Your Ref: OWQC23768
Our Ref: EP/74/19/HH
Please ask for:
Mr Z Denton

26th July 2019

Hip to barn hip extension, north dormer extension, single storey rear extension.
2 Hillview Crescent East Preston

Proposed Elevations

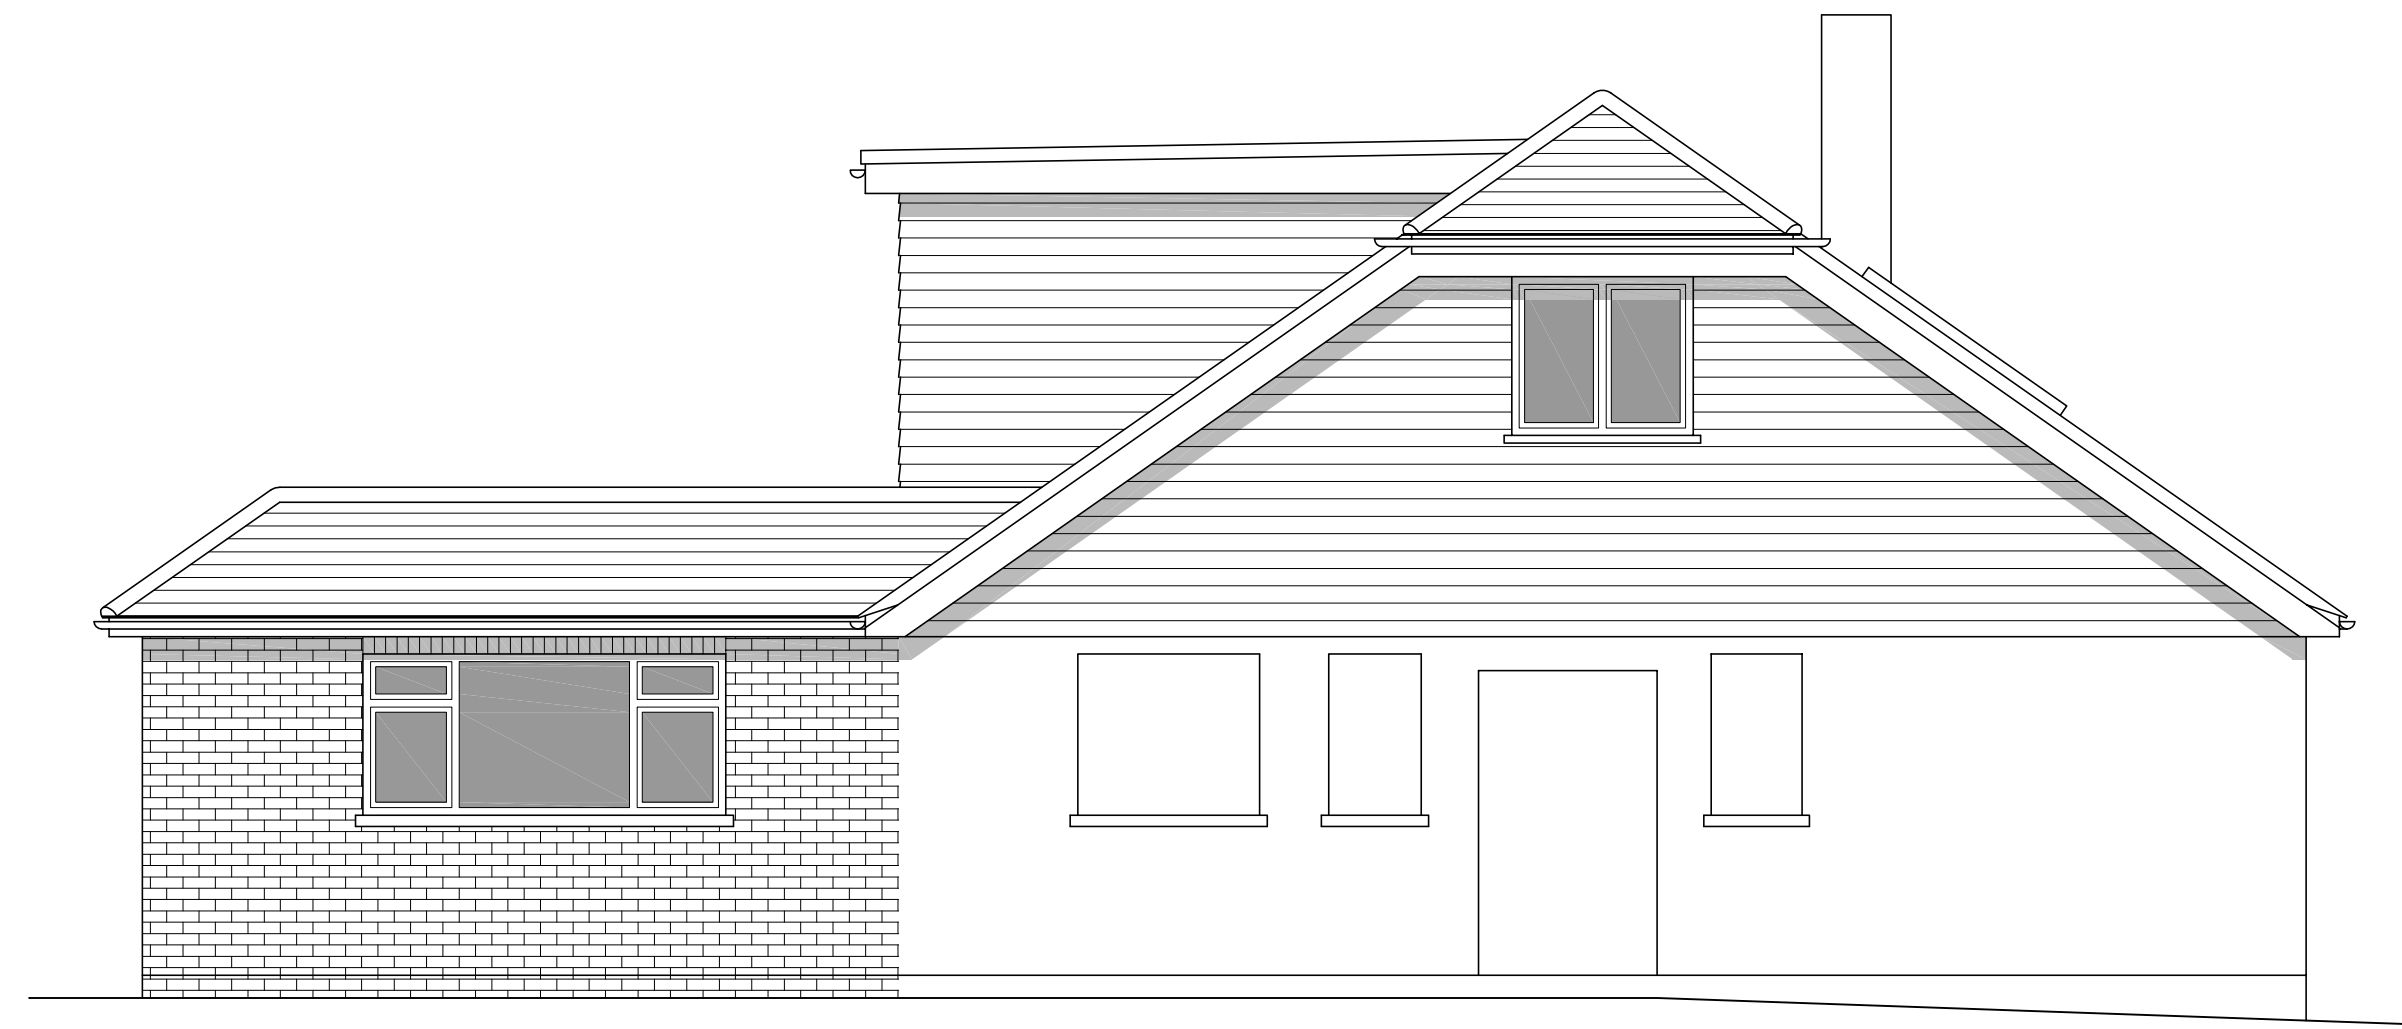
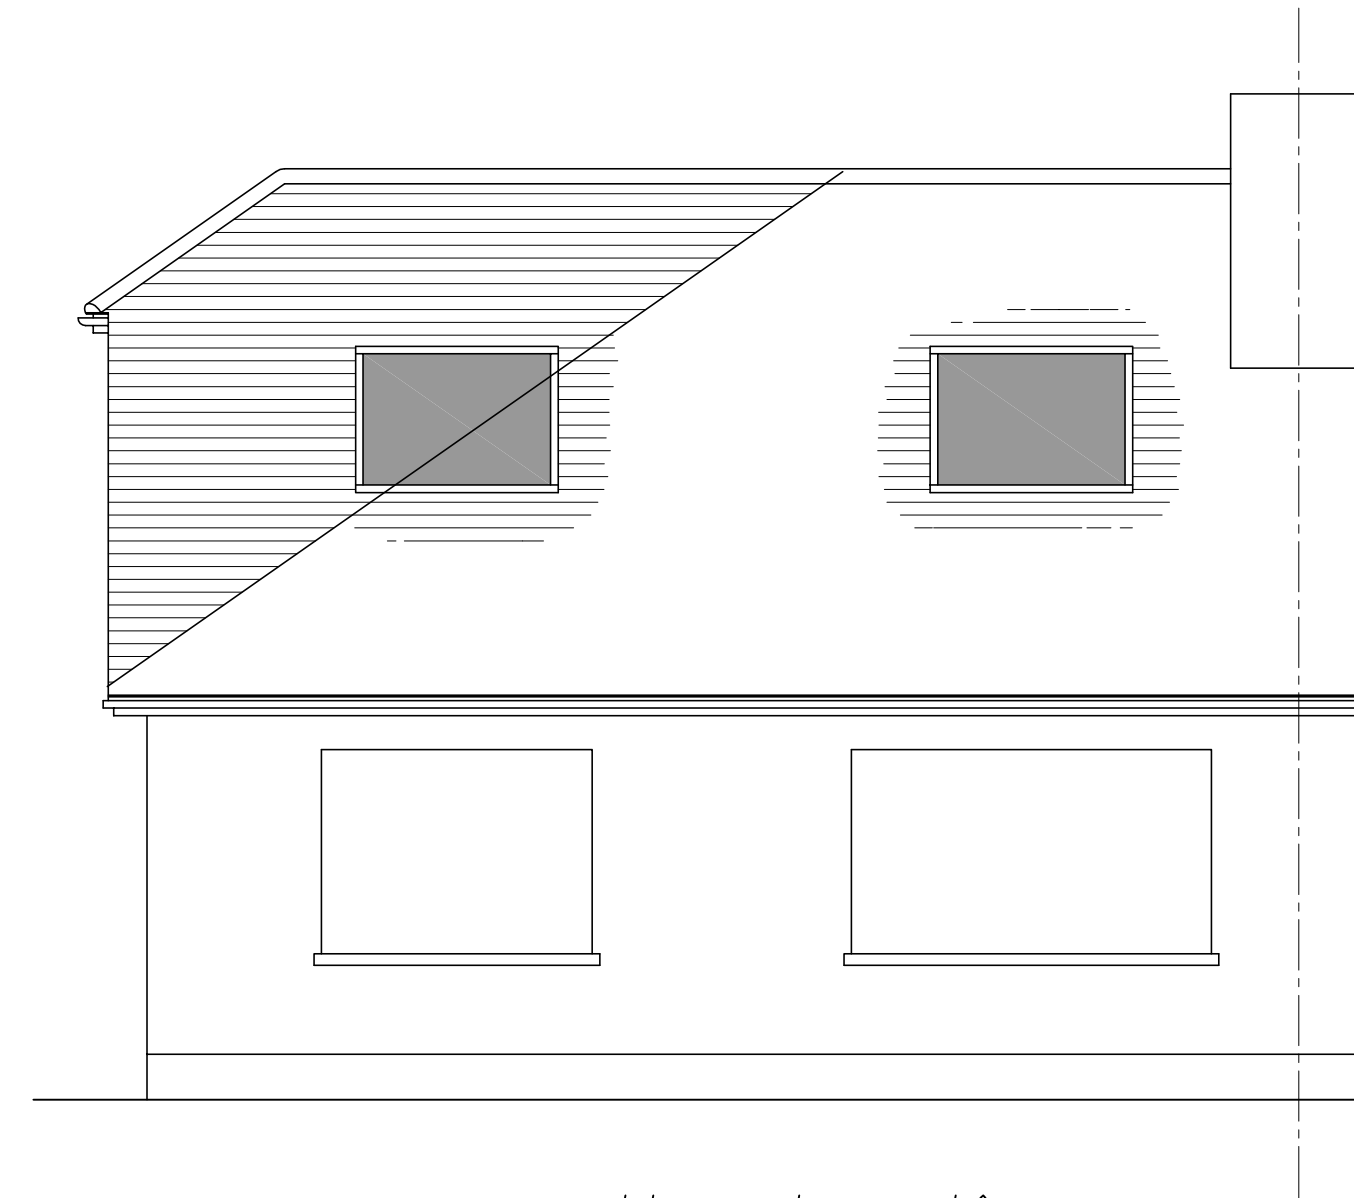
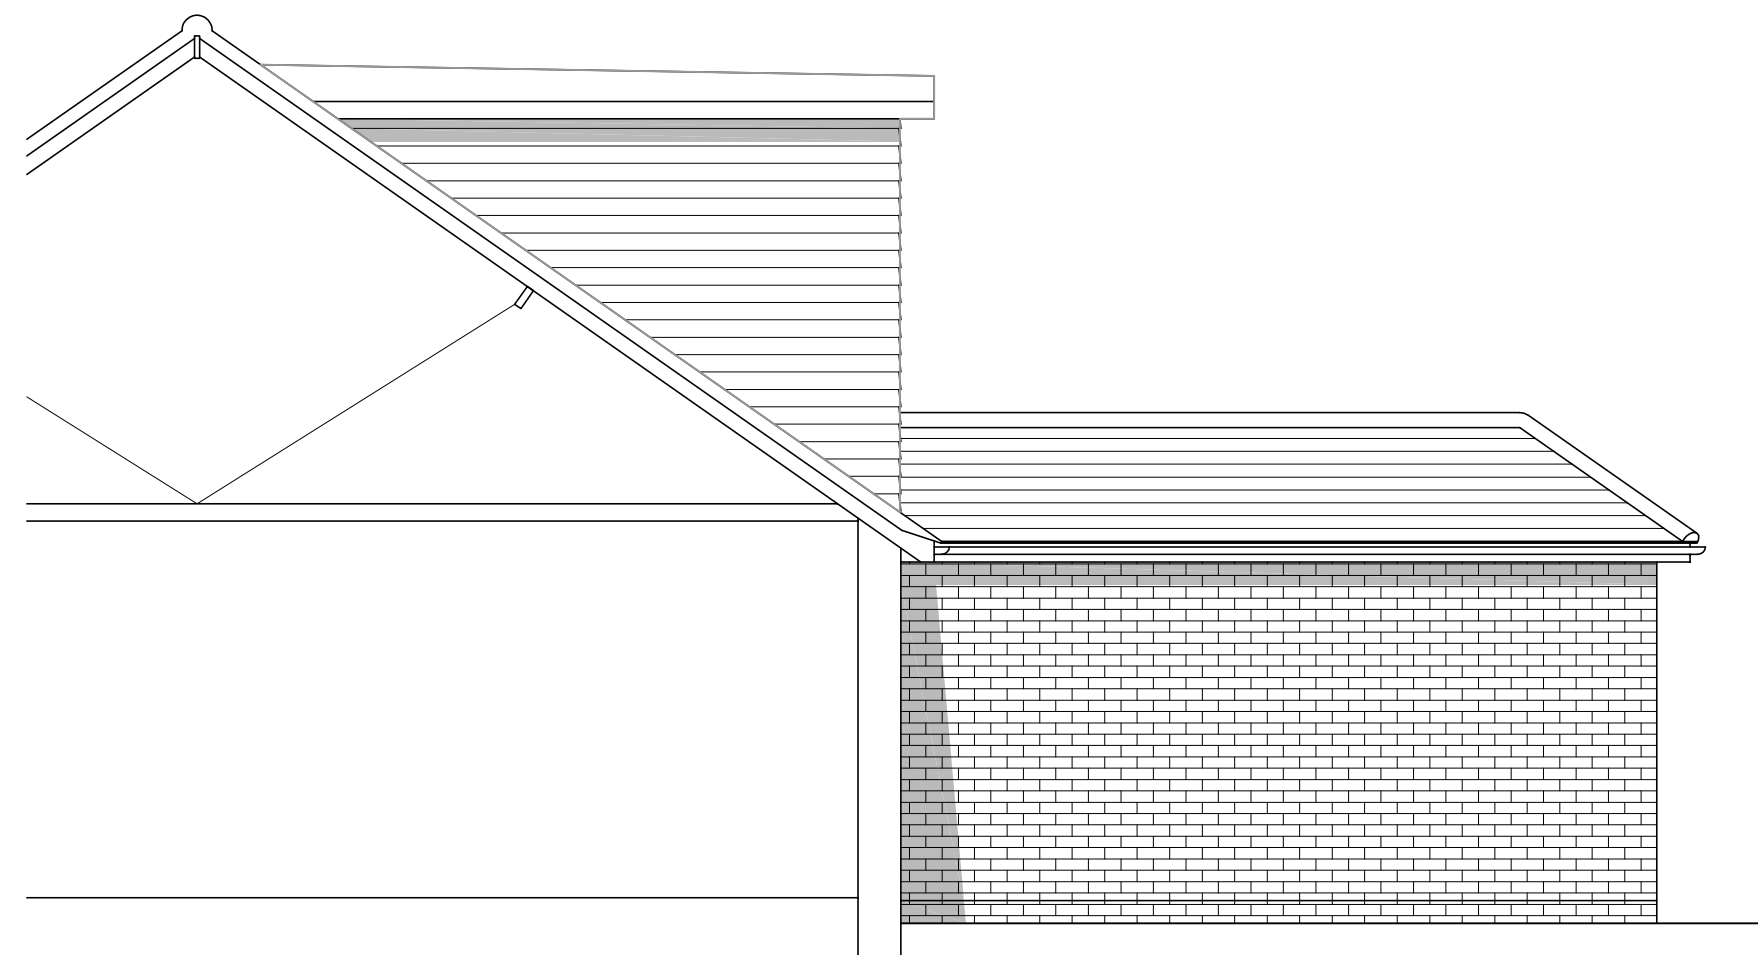
The committee agreed the revised proposal does not go far enough to meet the concerns of "unsympathetic design, significant size and prominent location" resulting in "an unacceptable discordant and incongruous impact upon the character and appearance of the host dwelling as well as that of the immediate locality contrary to policies D DM1 and D DM4 of the Arun Local Plan and Policies 1 and 3 of the East Preston Neighbourhood Plan".

The proposed dormer will overlook three adjacent gardens currently not overlooked.
